**Re: PA22-042 – Sunnyside Village Co-Housing – Technical Review 1**  
3121 66<sup>th</sup> Ave NE – APN: 29050300402100

**PRELIMINARY SUBDIVISION / CUP COMMENTS**

NO.	DATE	DESCRIPTION

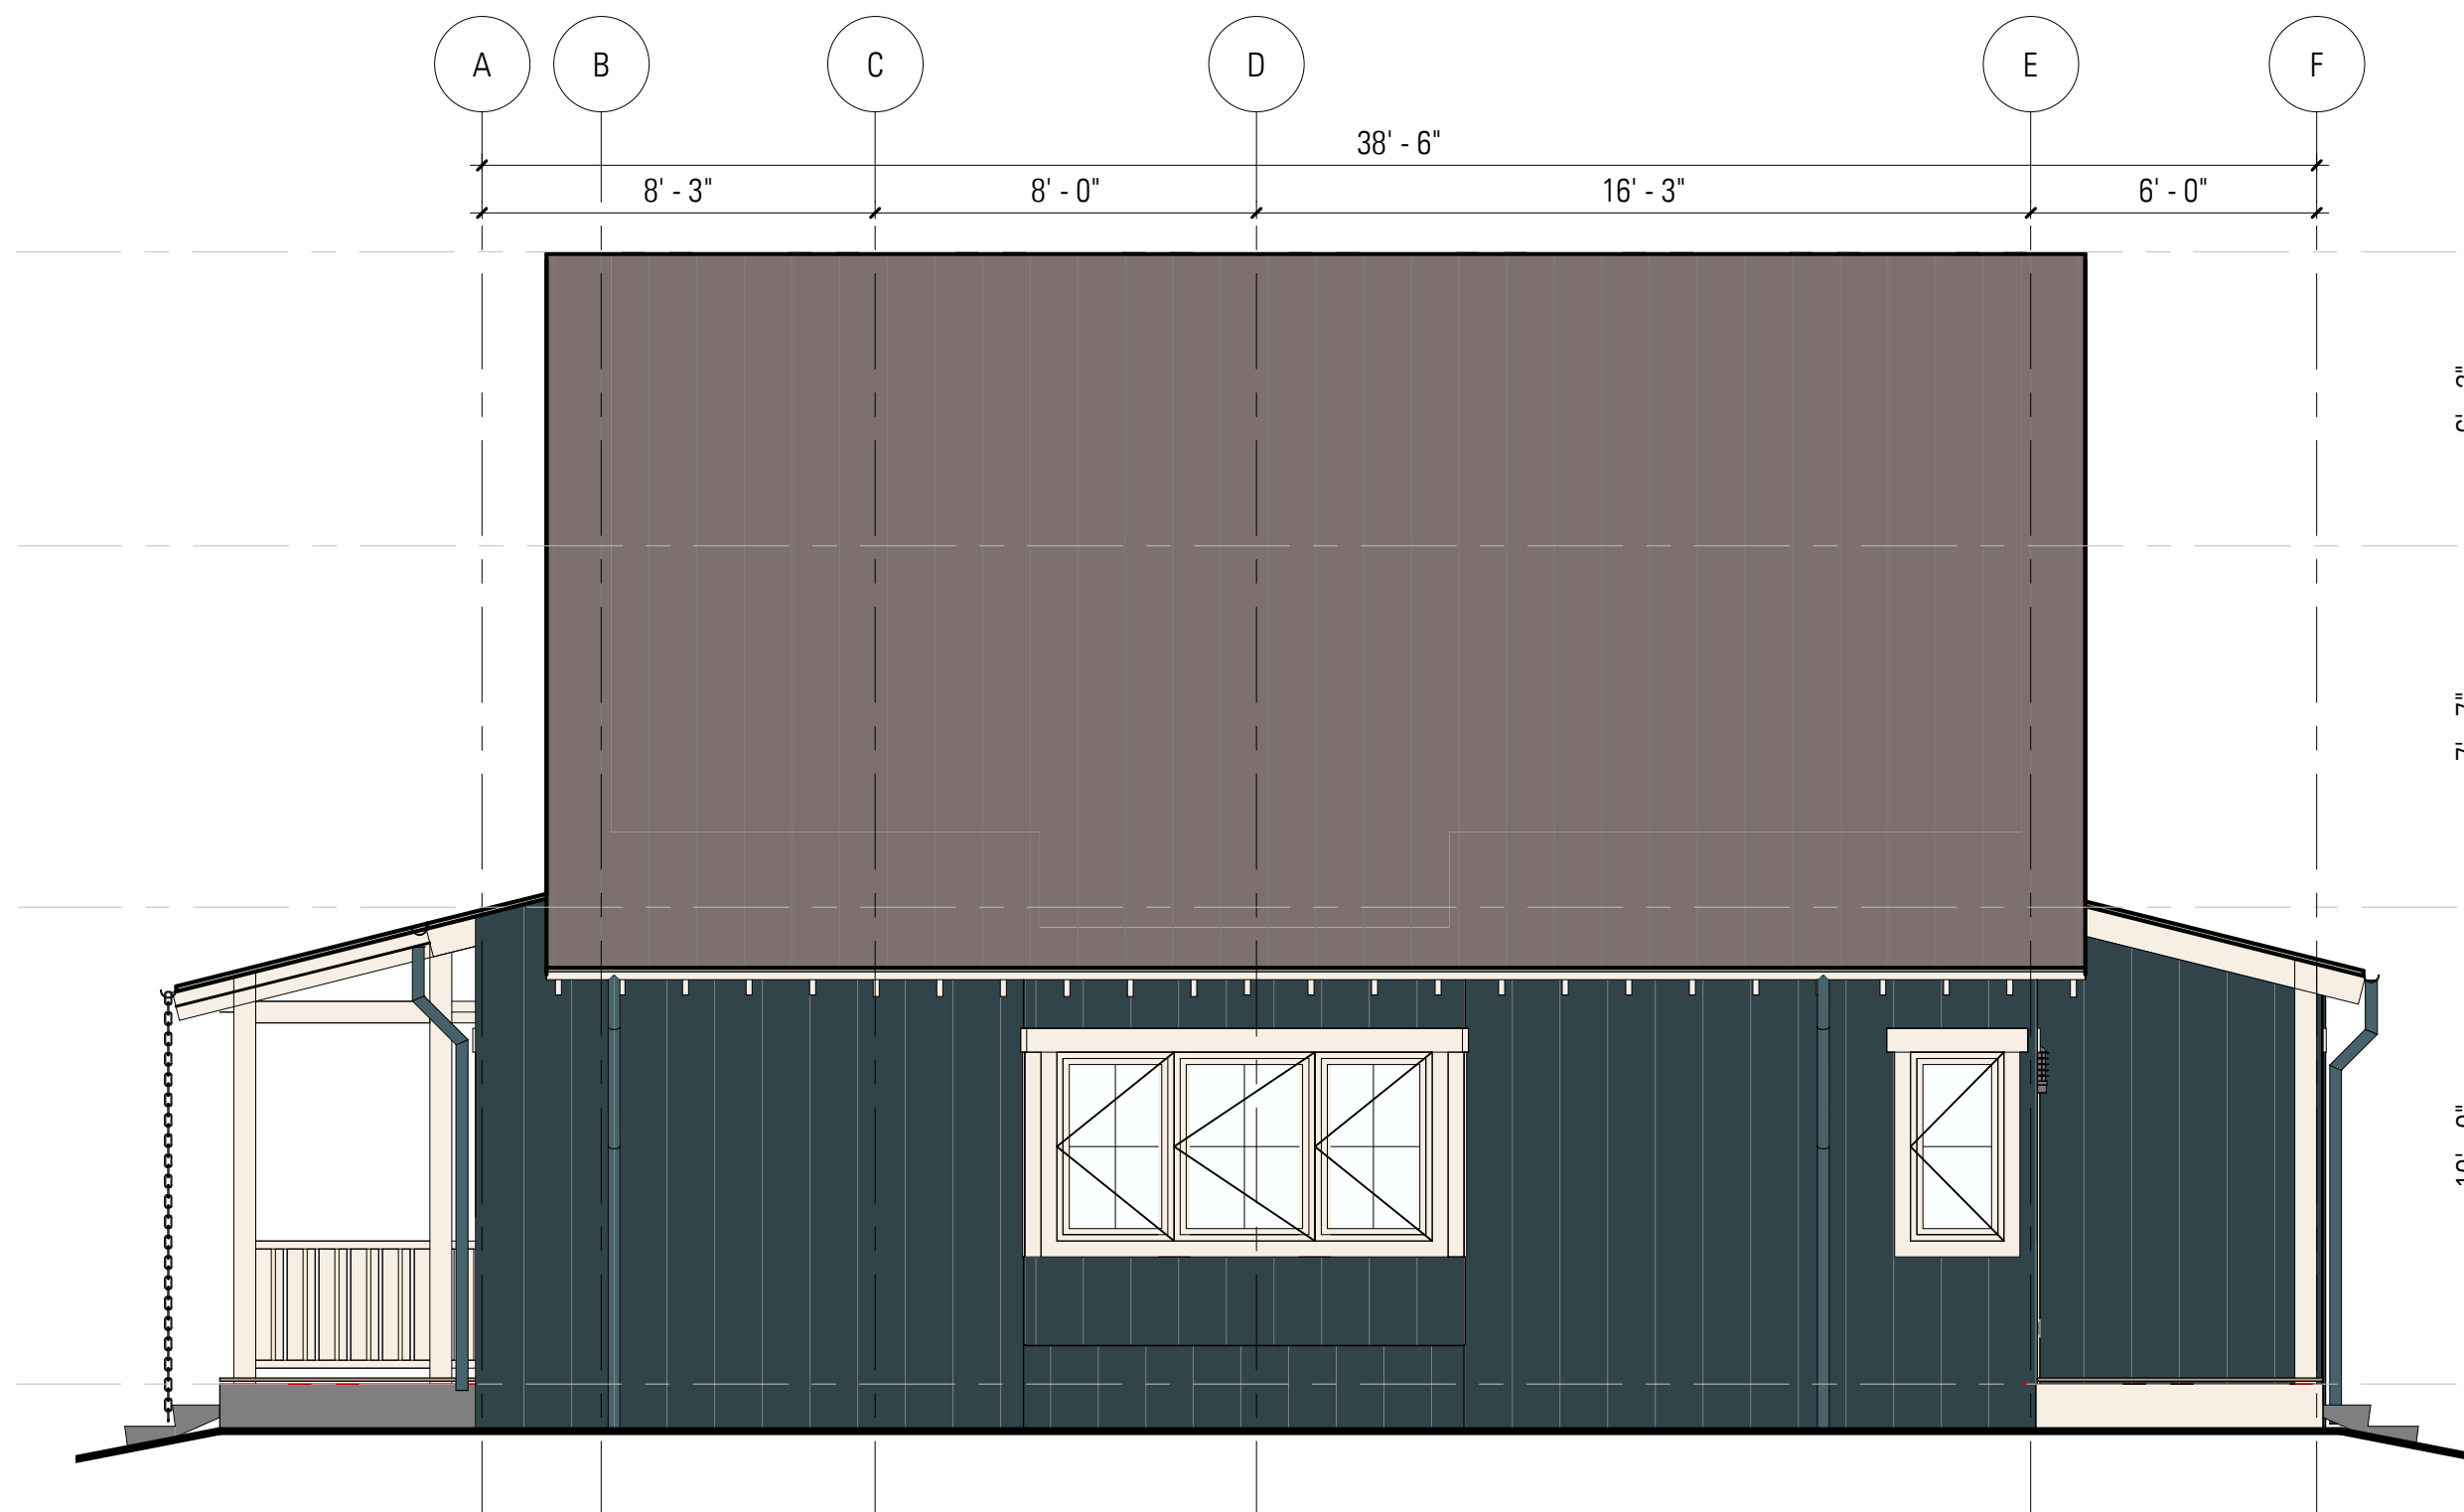
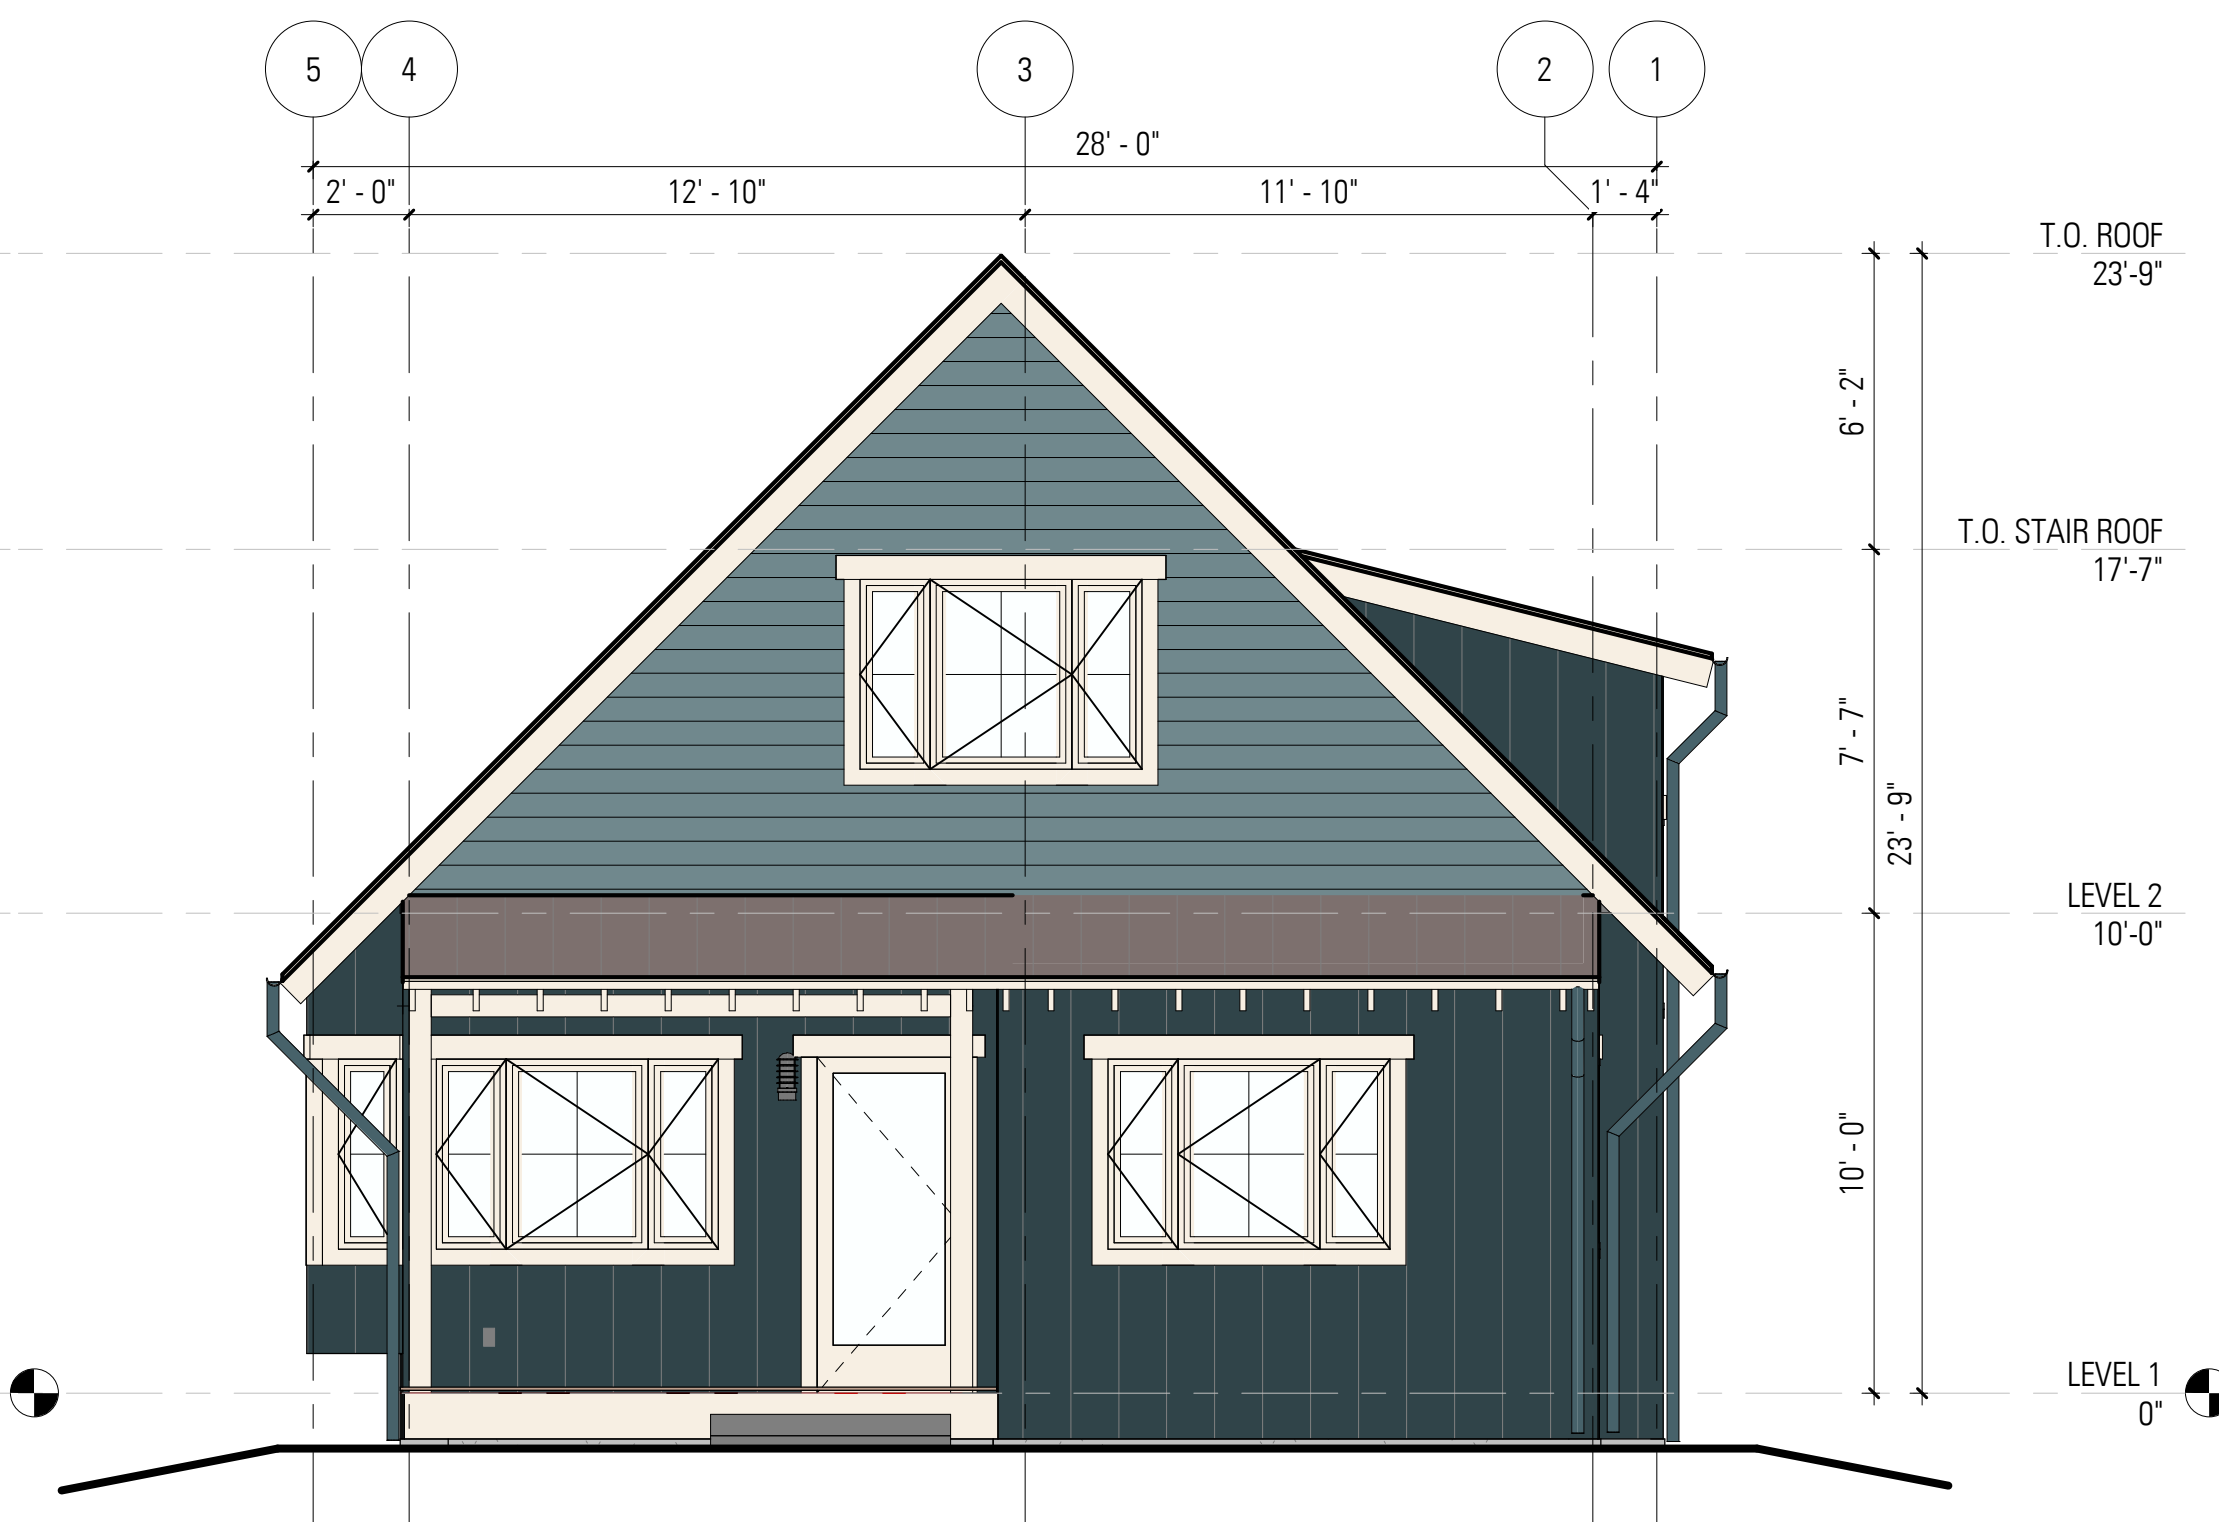
- 9. As proposed, the cottages do not appear to be visually different enough per MMC 22C.010.280(9). Proposed cottage plans A & B and C & D appear to be the same externally, with the exception of color. The cottages must offer a variety of visual interest, such as different roof forms, window design and entries.
